TOGA Central

Response to Submission

November 2022

Figure 12 Setback diagram

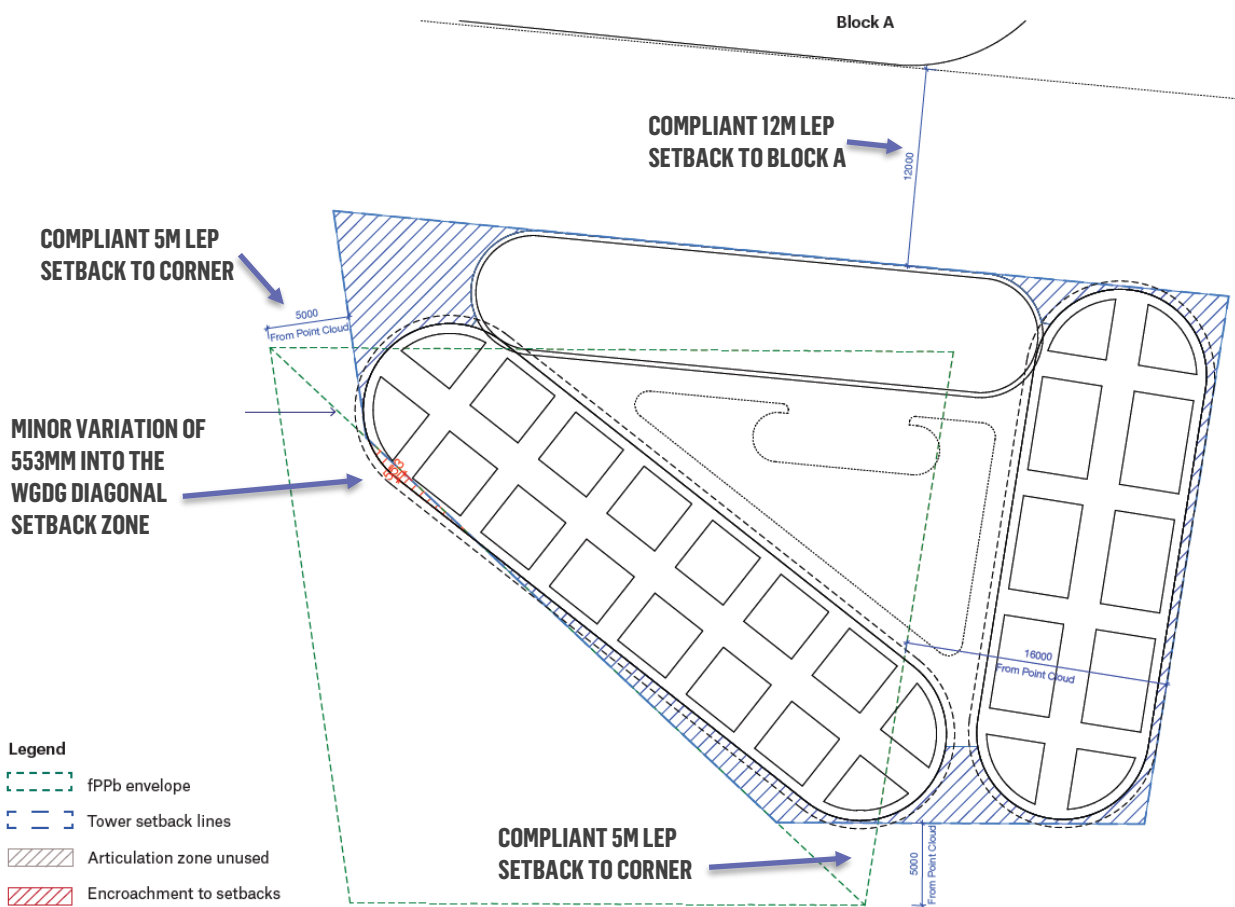
Provide an updated setback compliance plan that demonstrates the setbacks of the proposed building (instead of the building envelope) against the building envelope and setbacks established in the Western Gateway Design Guide and SLEP establish building envelope and minimum setbacks

The proposed design is consistent with the planning provisions contained in the Sydney LEP 2012 and the Western Gateway Design Guide. The expression of 3 distinct pill shaped elements resulted in areas of unused articulation within the envelope (ca 154 sqm), allowing greater views past the north-east corner and a western facade rotated in eastern direction, reducing visual impact from George Street. This led to a slight encroachment (ca 3 sqm) of the western diagonal setback line defined in the WG Design Guide.

To ensure a most accurate setting out of facade lines, all setback dimensions are based on a Point Cloud Survey of the fPPb. The site boundary has been omitted from the adjacent diagram for clarity, as this is not relevant to defining the setback lines.
